Development Referral No. DN20/0063

Proposal: Environmental Impact Statement (EIS) for alterations and additions to President Private Hospital (SSD-10320).

Property: 369-381 President Avenue, Kirrawee

West Carpark Detail Plan

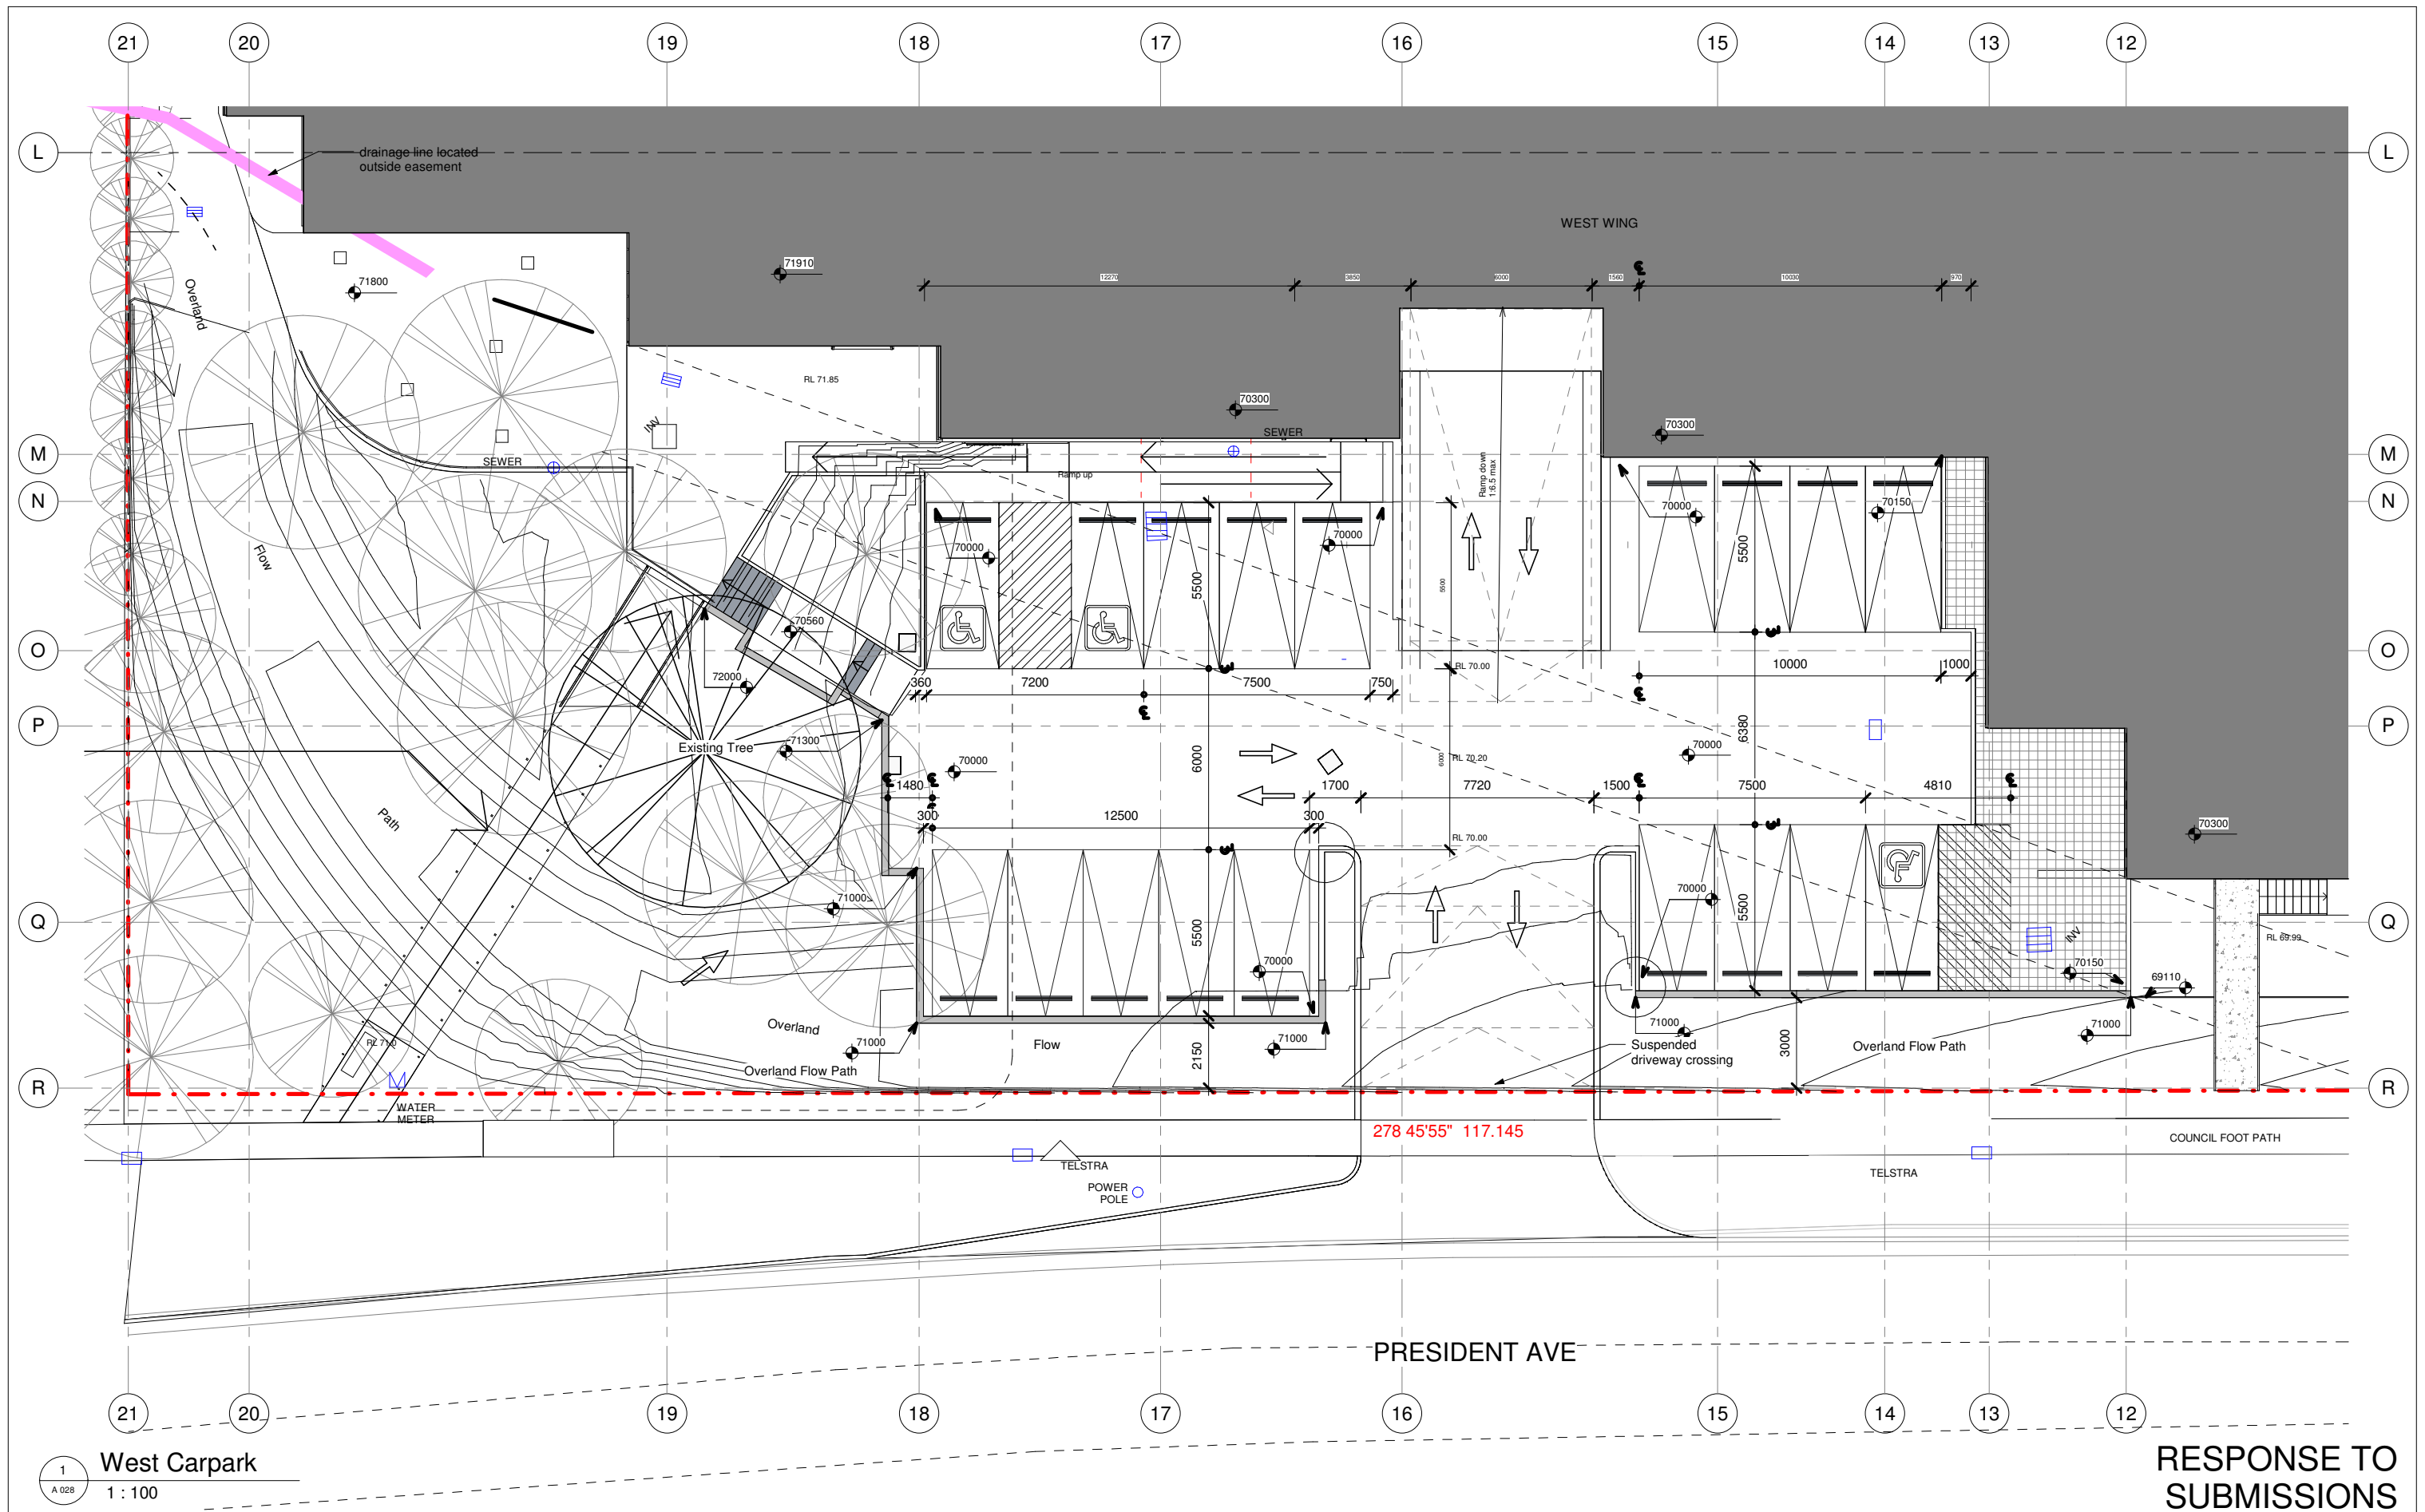
As part of original DA (DA02/1859) and subsequent DA (DA09/0929), a slip lane was considered necessary at the President Ave entry to the car park and a separate exit was proposed east of the car park. However, without a slip lane, an informal car park (without consent) has been operating since 2009 at this location with a capacity of around 10 parking spaces.

As part of proposed Hospital site expansion, for safety related to increase traffic volume at the President Ave driveway, it is recommended that a slip lane be provided at the President Ave entry to the car park with a separate exit to President Avenue for the proposed site. Without a slip lane, access to any significant parking from President Ave is a significant safety concern and will impact traffic on this very busy road. Alternatively, access should be provided off Hotham Road only.

A 402

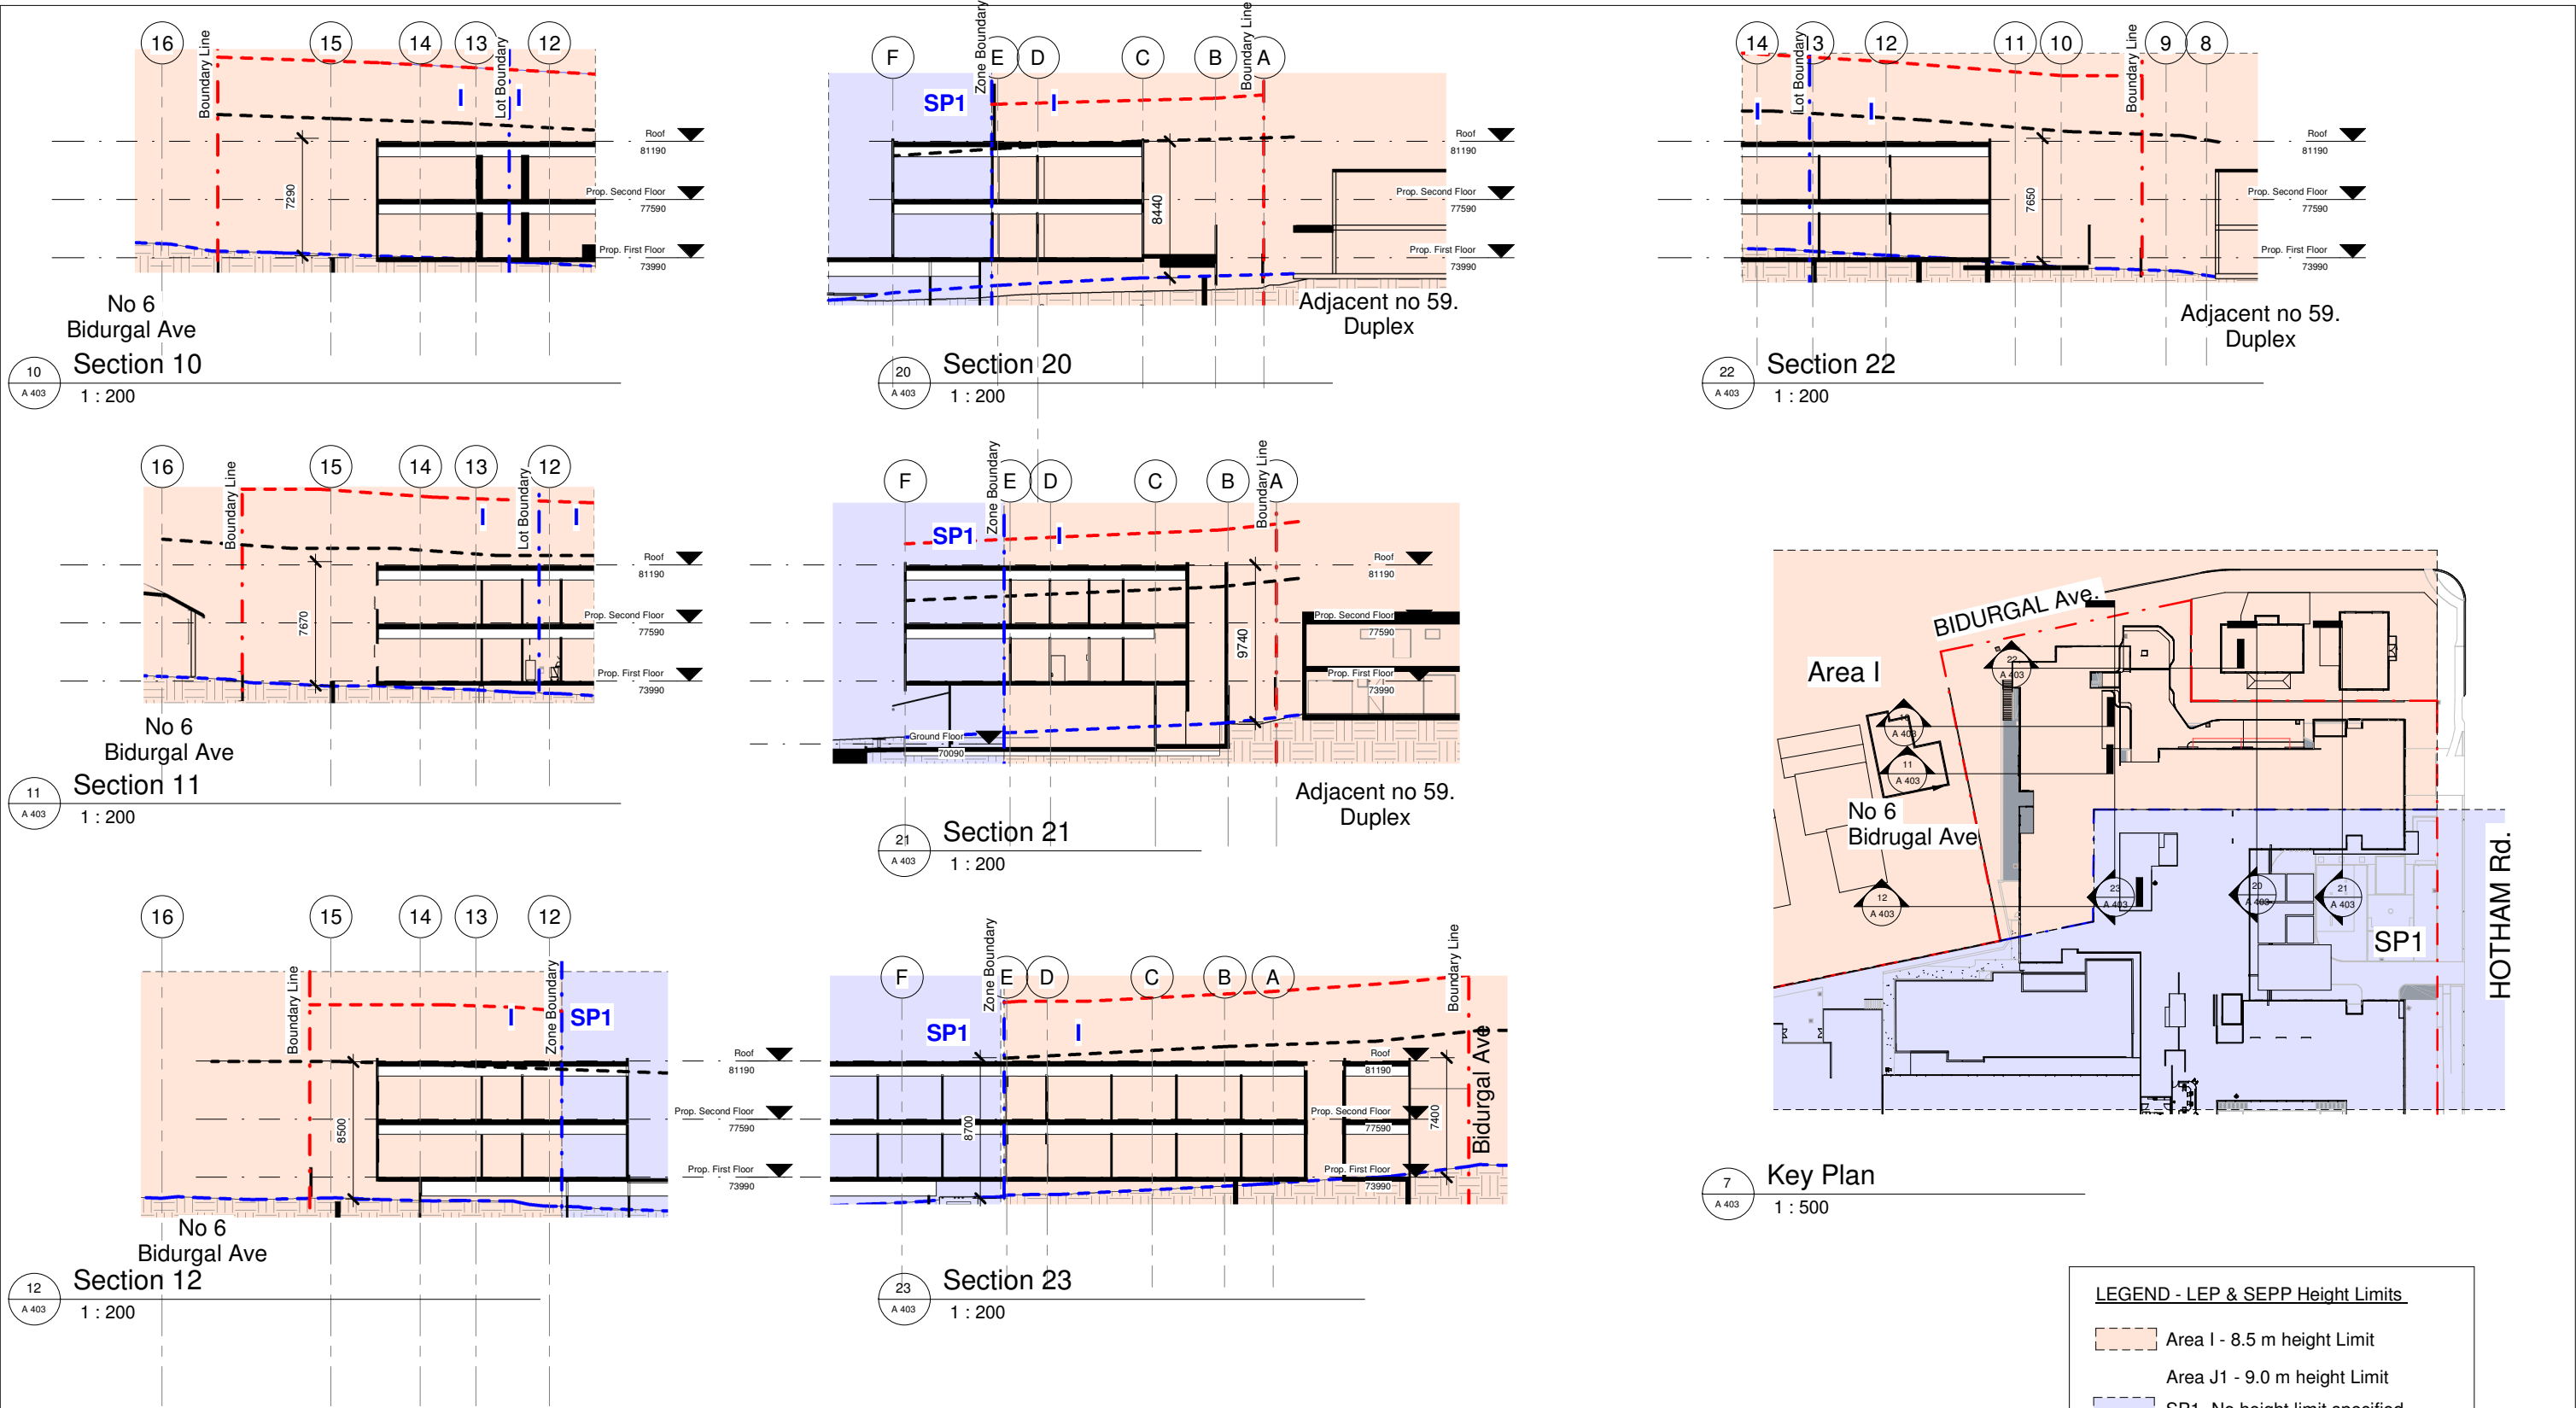
5. Tree 7 Araucaria columnaris – Cook Island Pine is shown to be retained. It is not believed that the levels shown on the architectural plans will allow this to occur. Section 02 shows the original ground line south of the tree's location lowered significantly. The sketch Perspective 2 – The Main Drop Off, shows retaining walls criss-crossing the tree protection zone. This zone requires 7.2 metres of existing ground levels to be retained right around this tree. If this doesn't happen, the tree will not survive the construction works around it. Driveway levels will need to be sympathetic to this trees root plate if it is to survive.
